REQUEST

Current Zoning: R-9MF(CD) (Multi Family Residential, Conditional)
Proposed Zoning: N2-A(CD) (Neighborhood 2-A, Conditional)

Approximately 5.00 acres located north of East W. T. Harris Boulevard, south of Briardale Drive, and east of East Independence Boulevard.

The petition proposes a residential community of up to 44 multi-family attached units on vacant land.

SHEET NO.
RZ-100

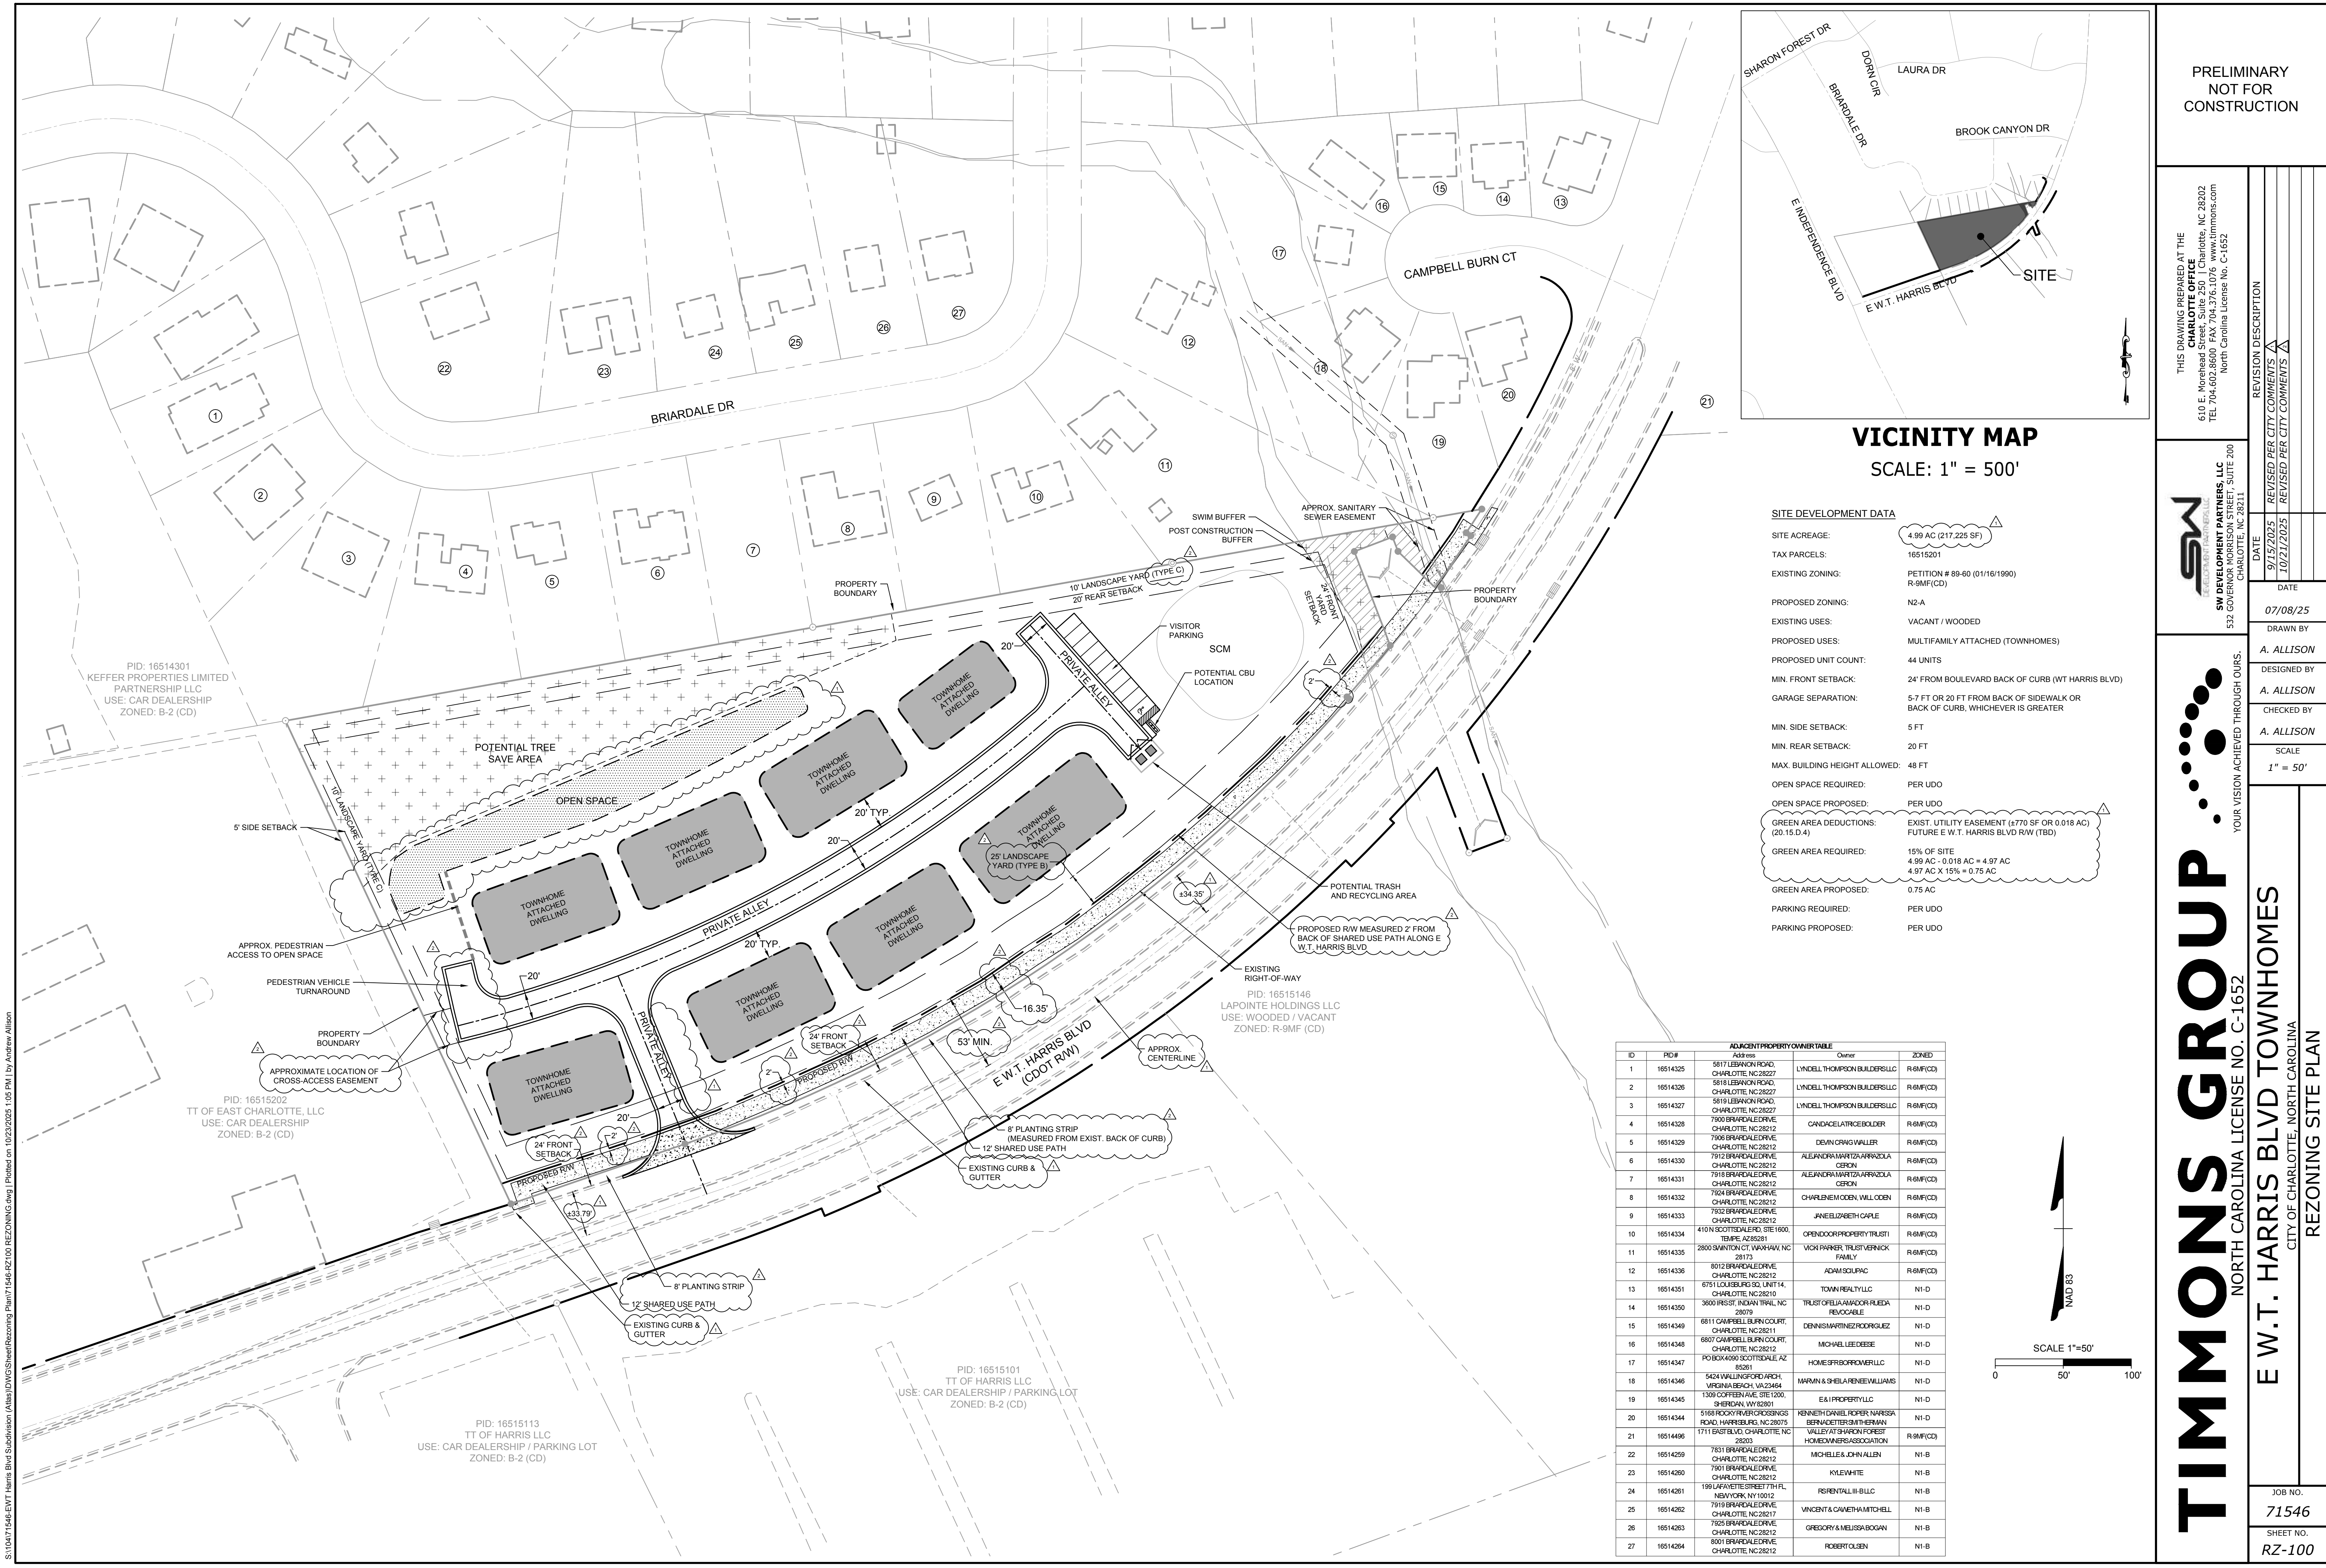
1. Revise site plan and conditional note(s) to commit to dedicate 53-feet of right-of-way from the road centerline. The site plan shall label and dimension the right-of-way from the road centerline. Additionally, 2-foot SUE must be added from the back of sidewalk.

2. Revise site plan and conditional note(s) to commit to constructing a 12-foot Shared-Use path along the entire site's frontage of East W. T. Harris Boulevard as required per UDO. Site plan shall label and dimension from the roadway centerline. During permitting, a fee can be paid towards STIP U-2509 in lieu of constructing an 8-foot planting strip and a 12-foot shared-use path in coordination with the City of Charlotte (Planning and CDOT). The completion of an Administrative Amendment would be required during permitting to do so. Add a conditional note committing to coordinating with the city of Charlotte (Planning and CDOT) and NCDOT during permitting to finalize the placement of the Shared-Use Path or the payment in lieu to NCDOT

3. Show the 10 buildings on the site plan or revise the conditional notes to commit to no more than 8 buildings as shown on the site plan.
4. Commit to a type of landscape yard.
5. Provide minimum stoop depth as 3-feet in notes.
6. Provide at least 4 elements for open space.
7. Per 31.2 provide cross access and easement to the property to the west.
8. There is a 12-foot sidewalk, and 8-foot planting strip required.
9. Label the centerline and show R/W dedication from the centerline to 2-feet behind the sidewalk.
